CONSTRUCTION DOCUMENTS - GRADING

CBP, F2-LOT #21 - CRACKERJACK MUD JACKING, INC

7315 McCLAIN POINT, COLORADO SPRINGS, CO

EL PASO COUNTY

GRADING PLAN

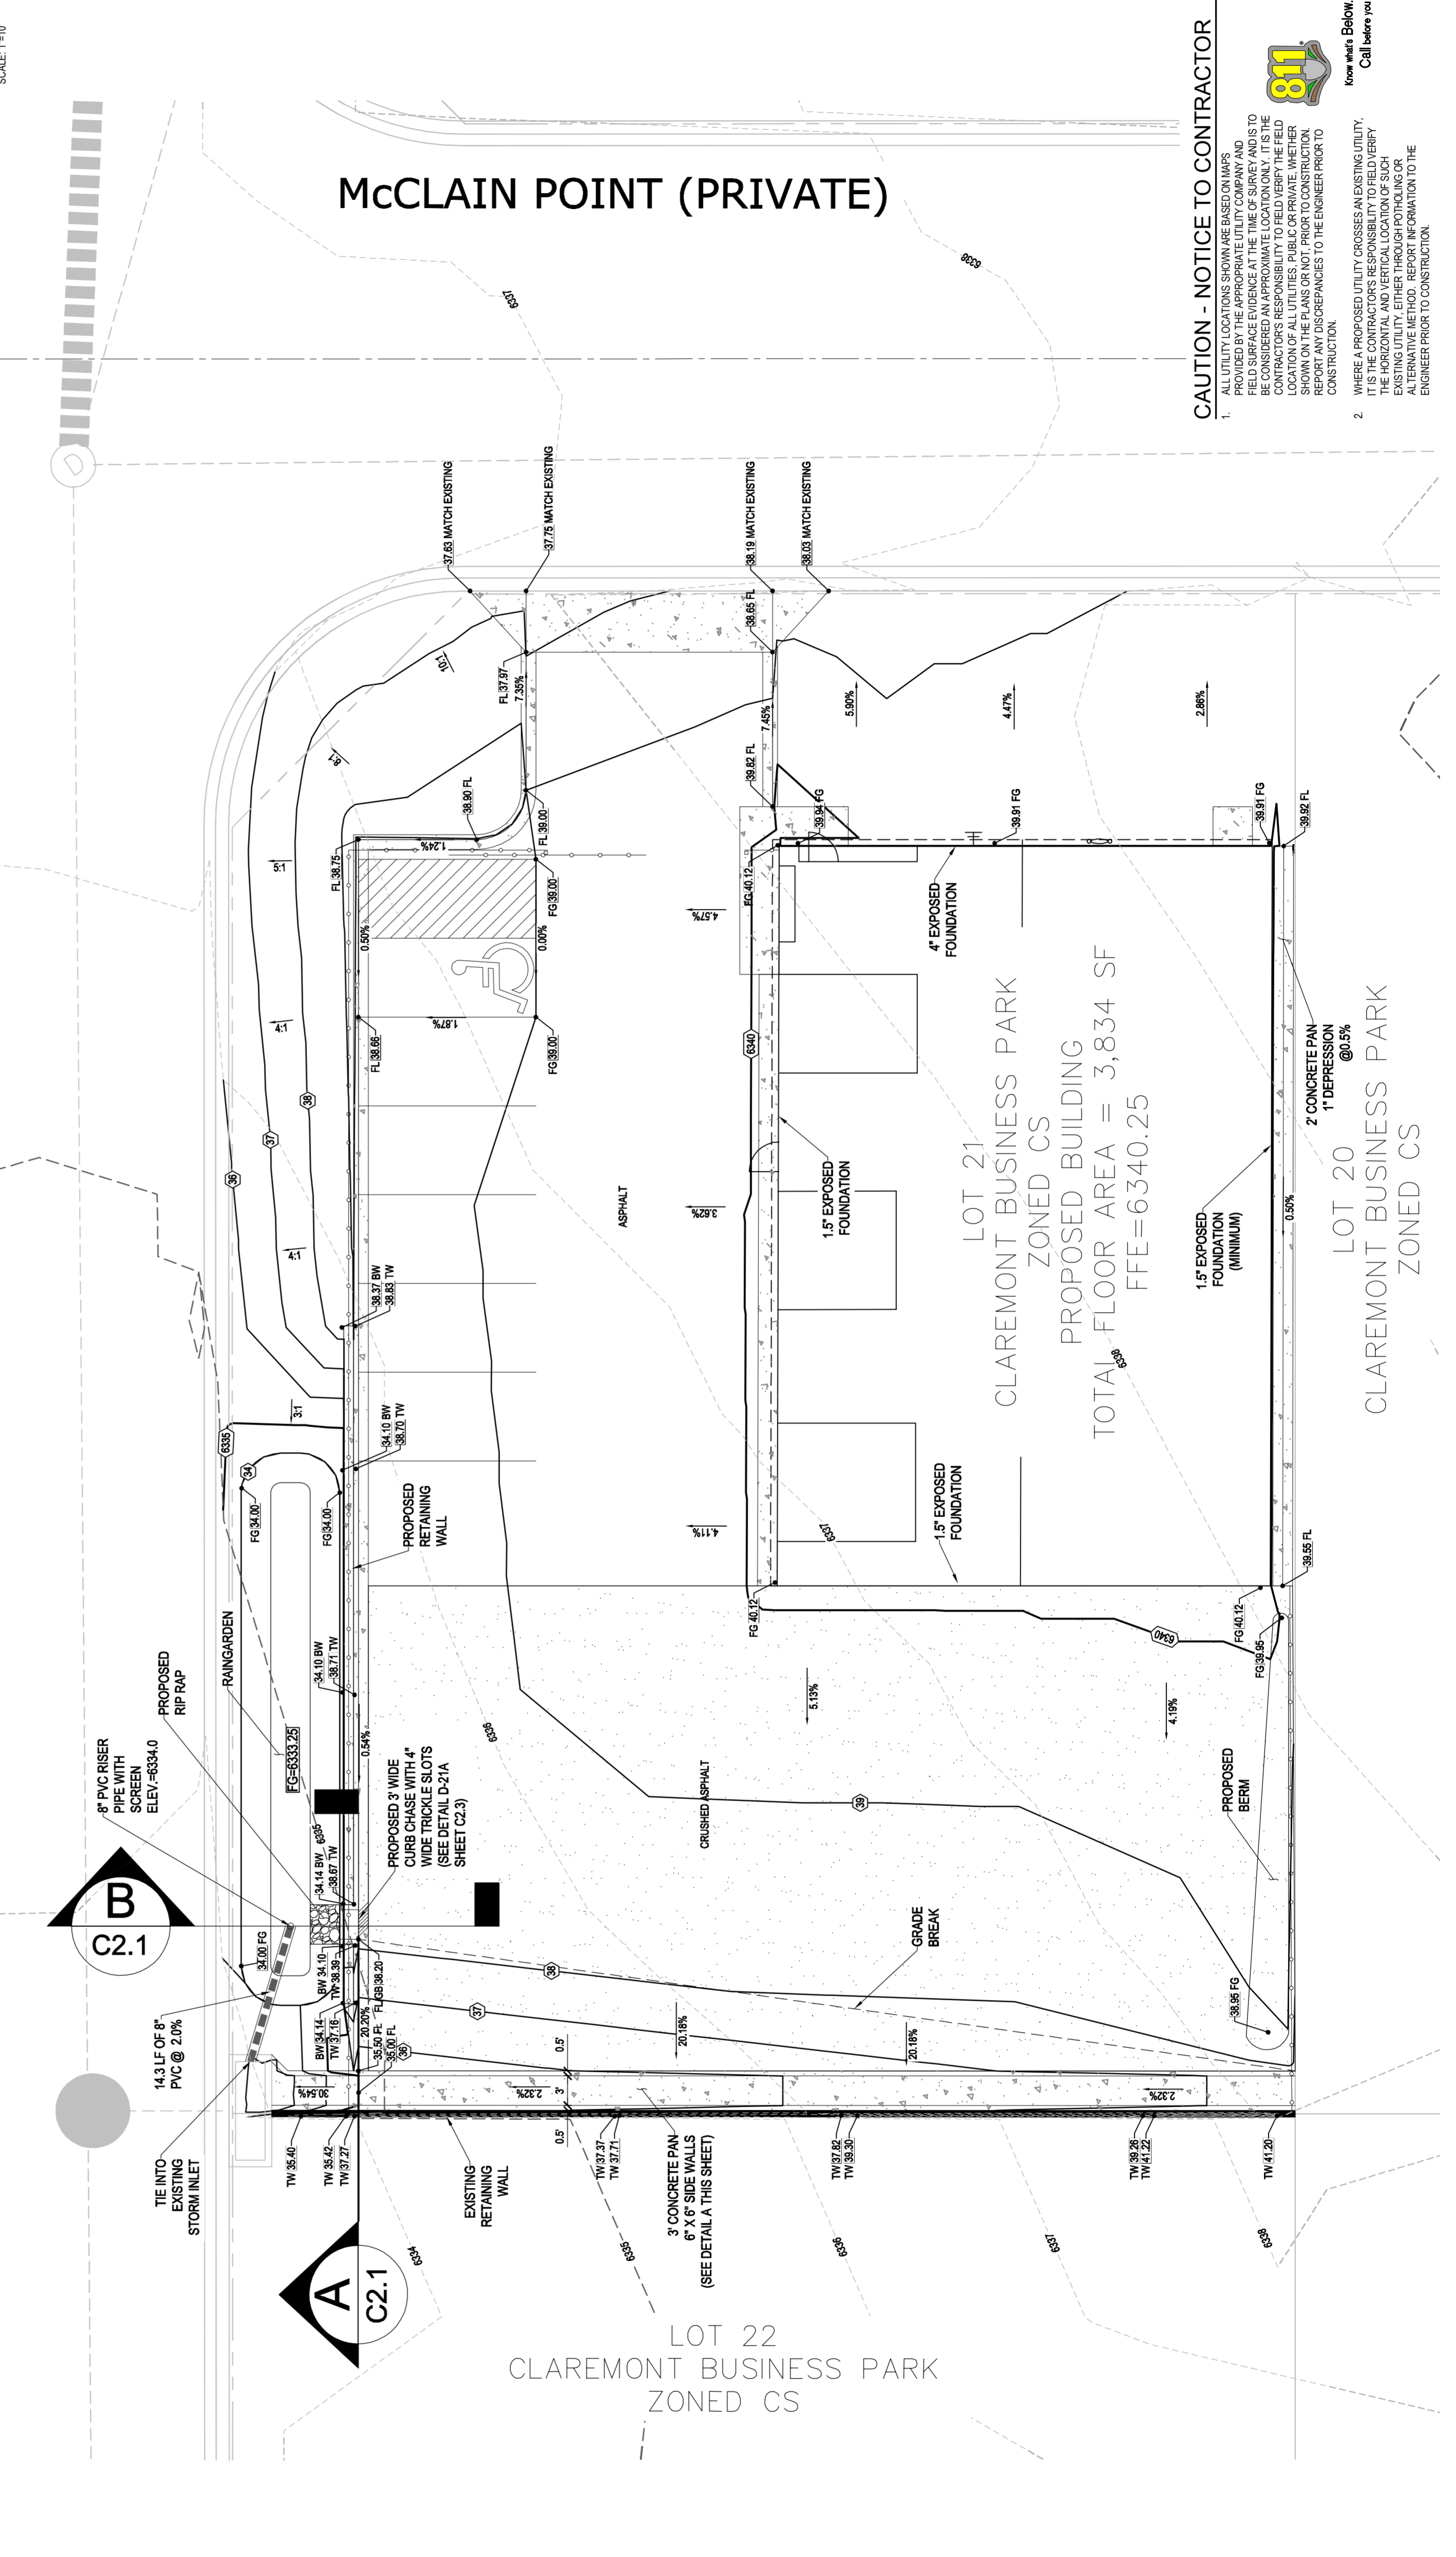
Callout the lowest top of curb elevation fronting the rain garden.

Identify the riprap LxWxD and D50 Size.

Show the actual retaining wall cross section which includes the footers.

Since the retaining wall is greater than 4 feet in height building permit is required.

Therefore, add a callout stating a building permit is required for the retaining wall.
